May 24, 2017  
(Revised 6-6-17)

Project Name: **547 Riverside Street: 504-unit self-storage facility**  
Project ID: #2017-025 (Site Plan and Site Location of Development)  
Address: 547 Riverside CBL: 312/B/008-012  
Applicant: Bob LeBlanc  
Planner: Matthew Grooms

RE: Staff Review Comments for 547 Riverside Self-Storage Containers (2017-025)

DRAWING NO. **C-10**

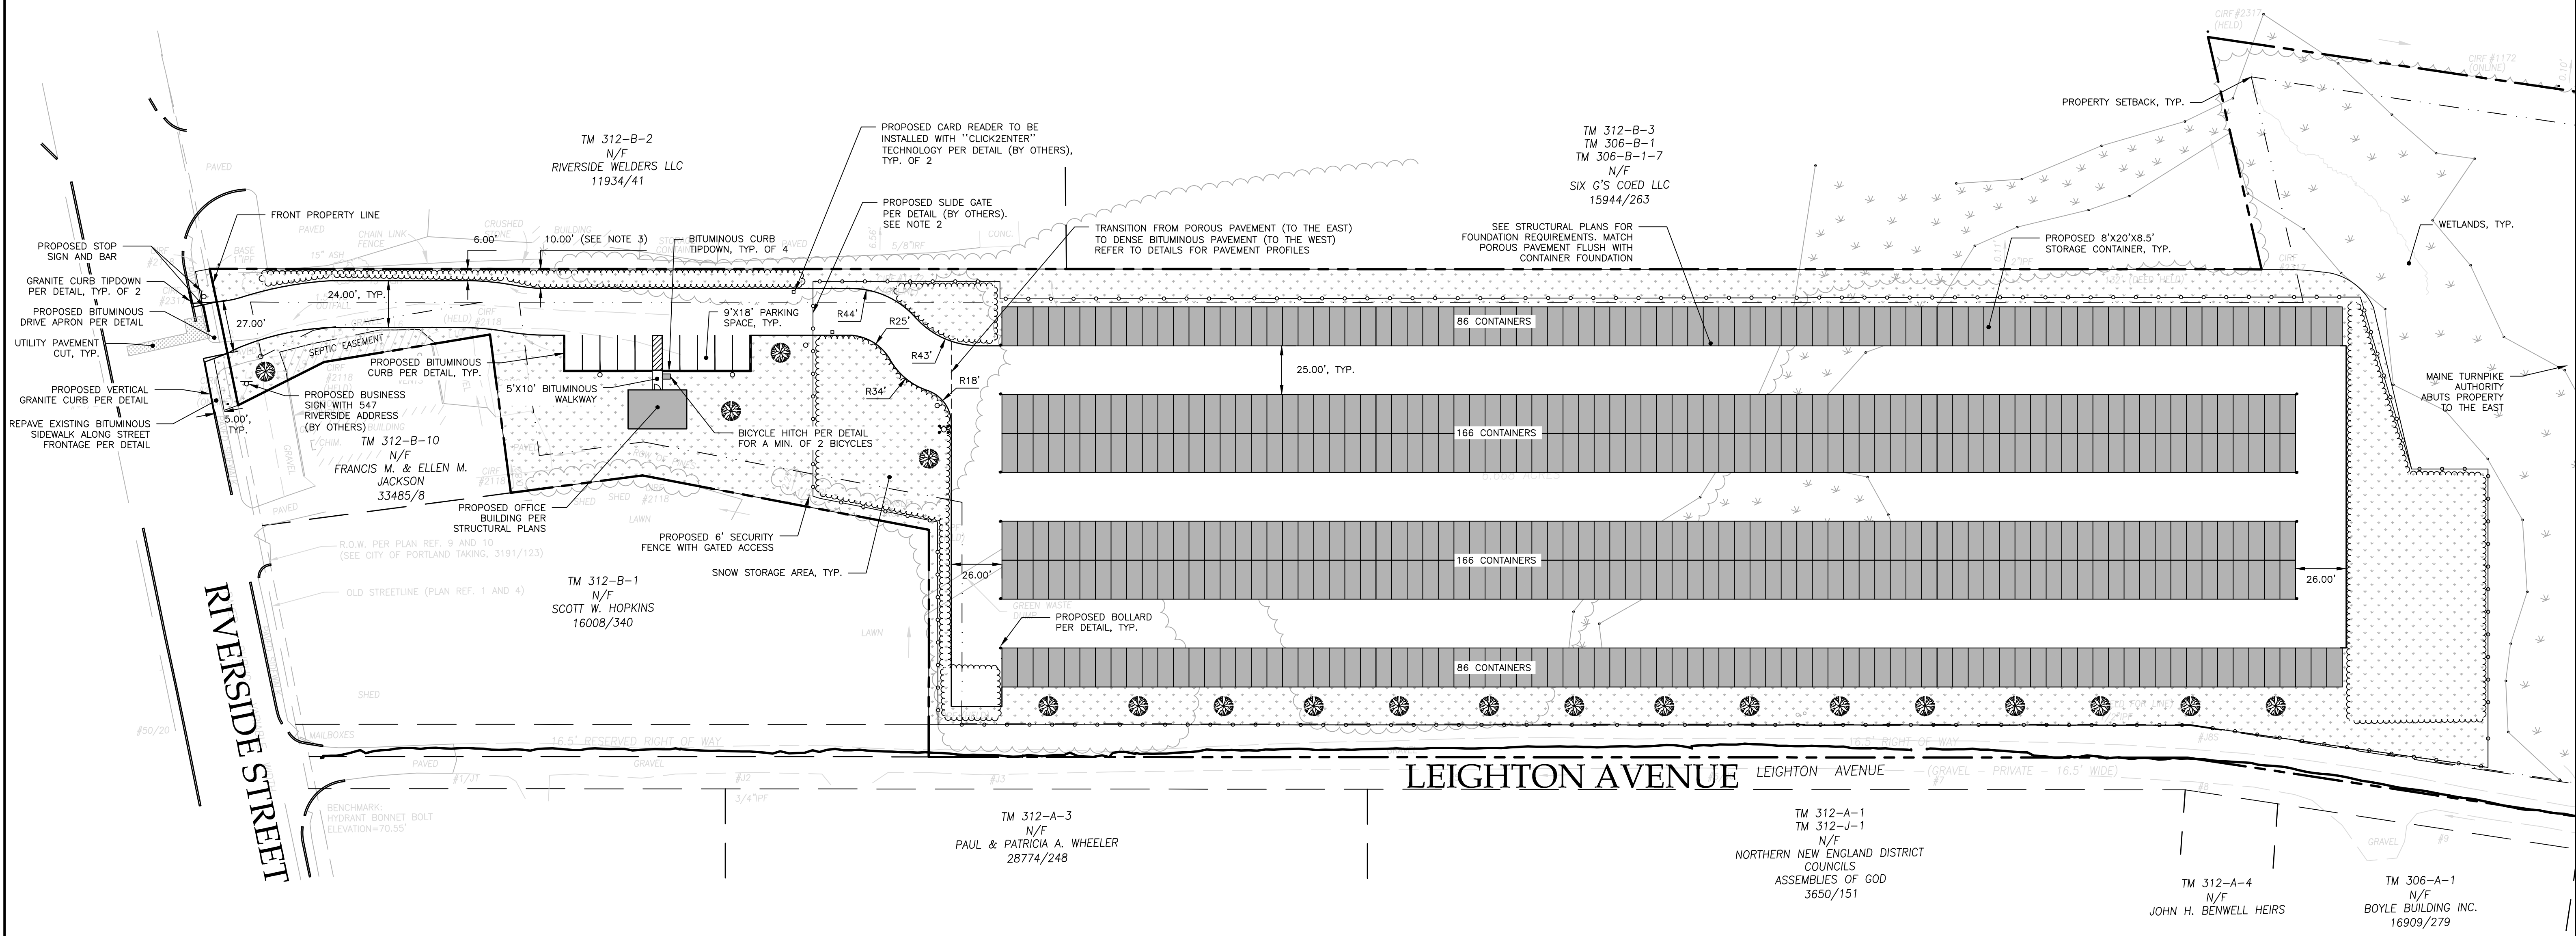
5. Per Section 14-250(h), the pavement setback from lot boundaries shall be a minimum of 10' feet. Past the choke point, approximately 140' feet east of the property line along Riverside Street, it appears that the edge of pavement is just 6' feet from the northerly property line. Past this bottleneck, the driveway shall be relocated to meet the city's 10' feet standard.

11. On Sheet C-10, Site Plan, a proposed sliding gate is called out with reference to a separate detail and "Note 3". There does not appear to be a "Note 3" and in looking at the two site detail sheets, there does not appear to be a detail for either the 6' foot security fence or gate. These items shall be included with the subsequent submission.

DRIVEWAY SLOPES ON SIDEWALK SECTION
NOT TO SCALE

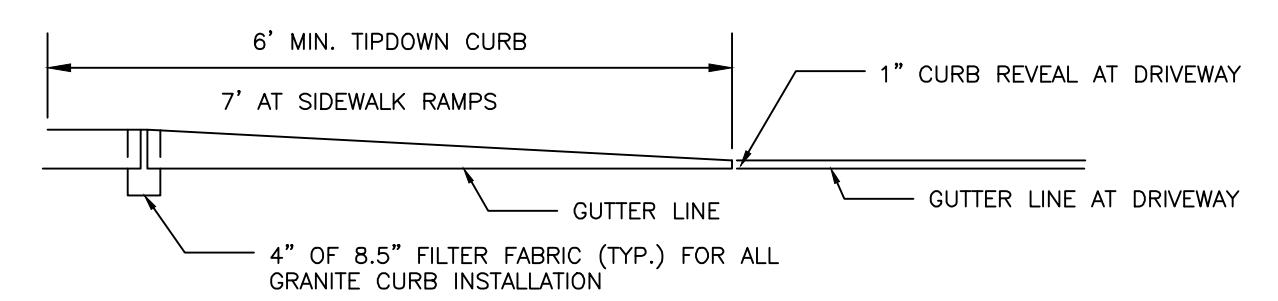
- The driveway shall be designed such that a maximum cross-slope of 2% is provided along the sidewalk accessible route.

**Status: The applicant has noted that the plans include this requirement and therefore I have no further comment.**

**EROSION CONTROL BLANKET SLOPE INSTALLATION**

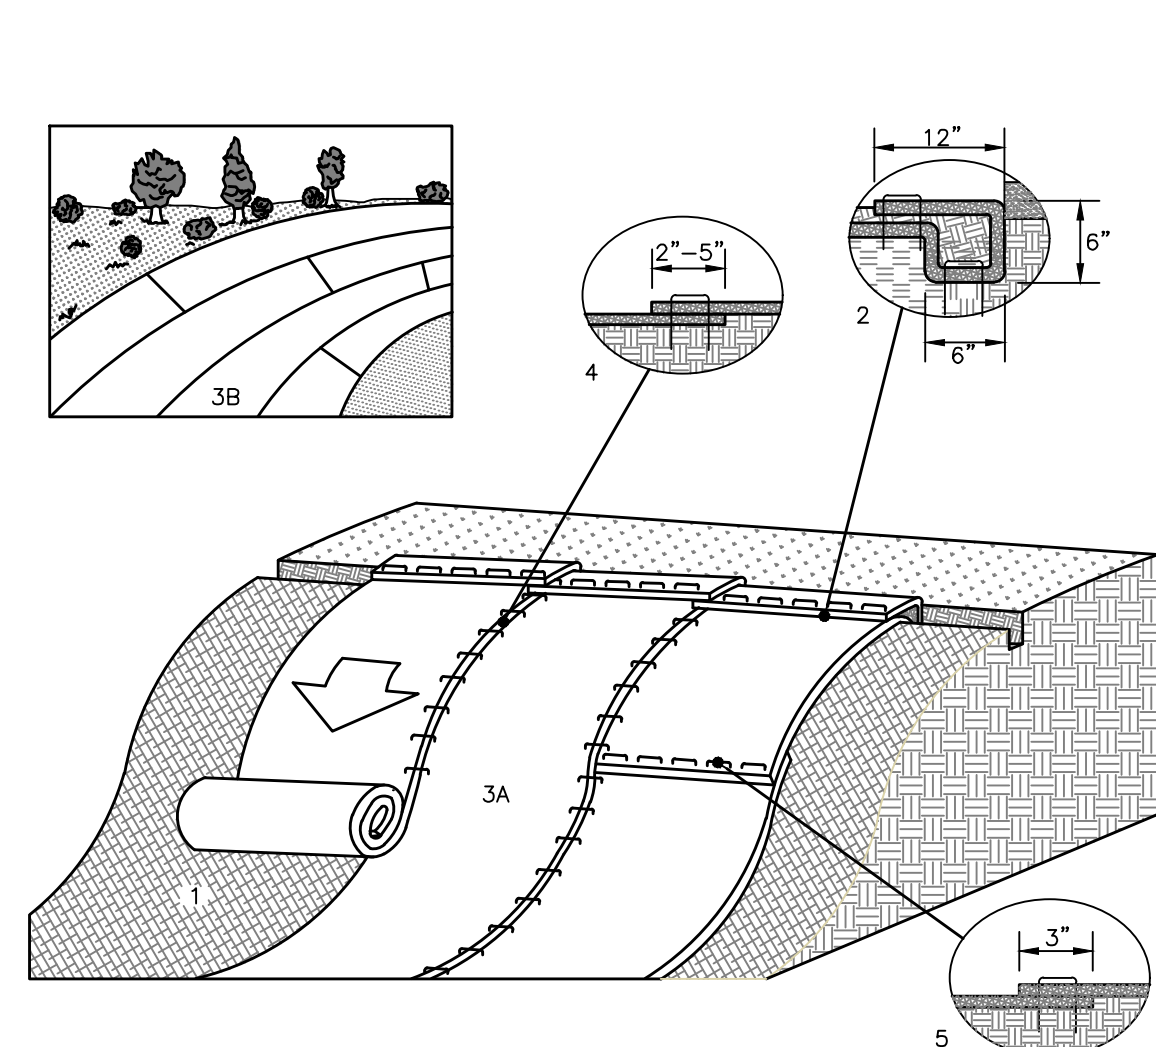
- We recommend that the Applicant consider erosion control blanket on proposed perimeter slopes, to help prevent erosion onto adjacent properties.
  - b) General Standard: The project will result in an increase in impervious area of approximately 3.5 acres and is required to include specific stormwater management features for stormwater quality control. The Applicant is proposing to treat stormwater using a pervious concrete stormwater filter system.

**SILTATION FENCE DETAIL**

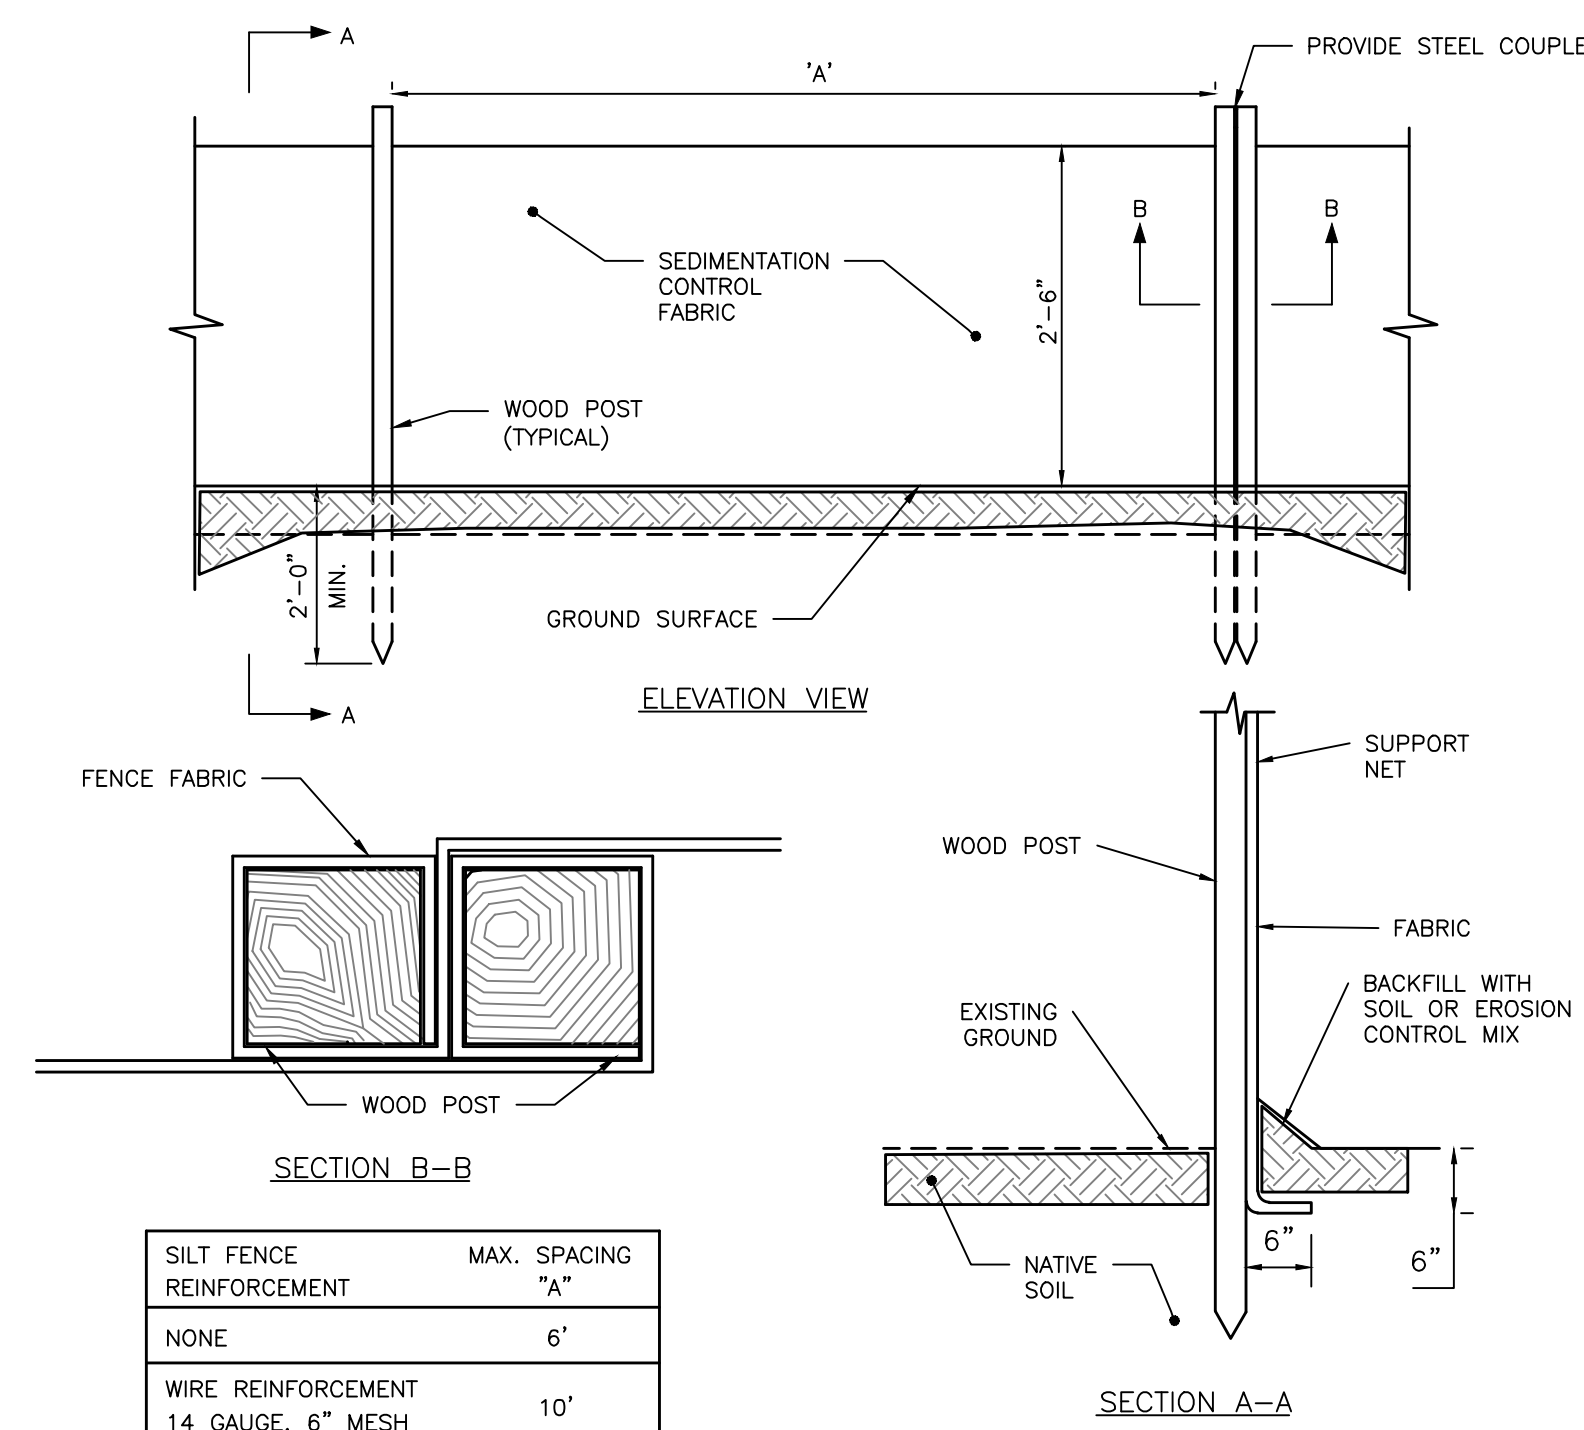
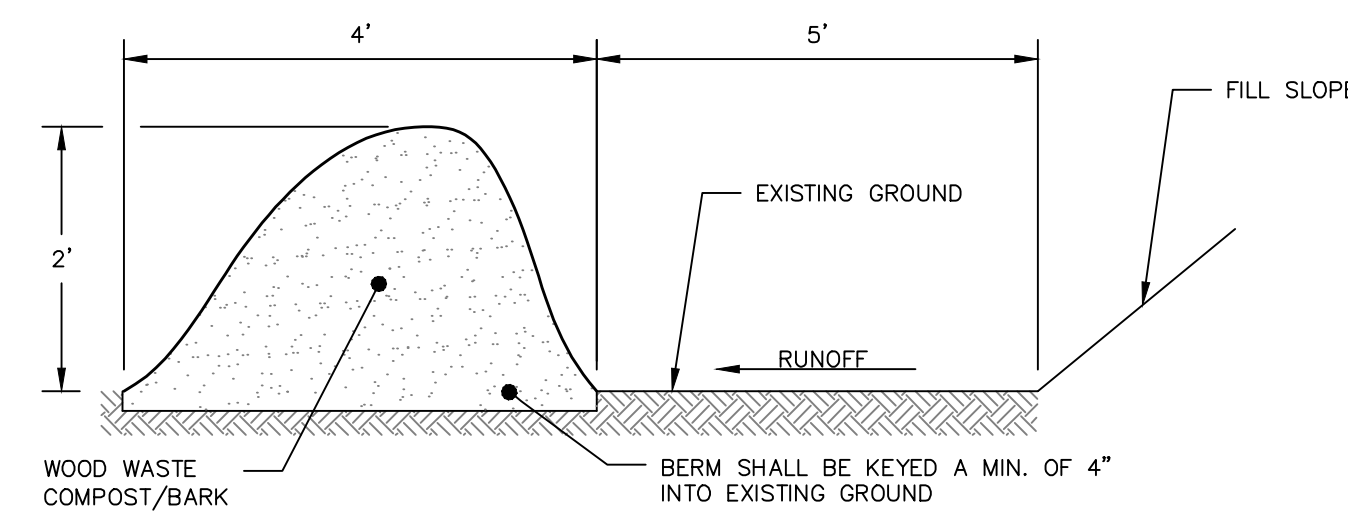
- It is noted that the plans call for the use of an erosion control berm, but the detail provided is for silt fence. The Applicant should clarify.
    - Based on proposed grading, it appears that the sedimentation barrier should extend along the northern and southern edges of the property, in addition to the areas currently shown.
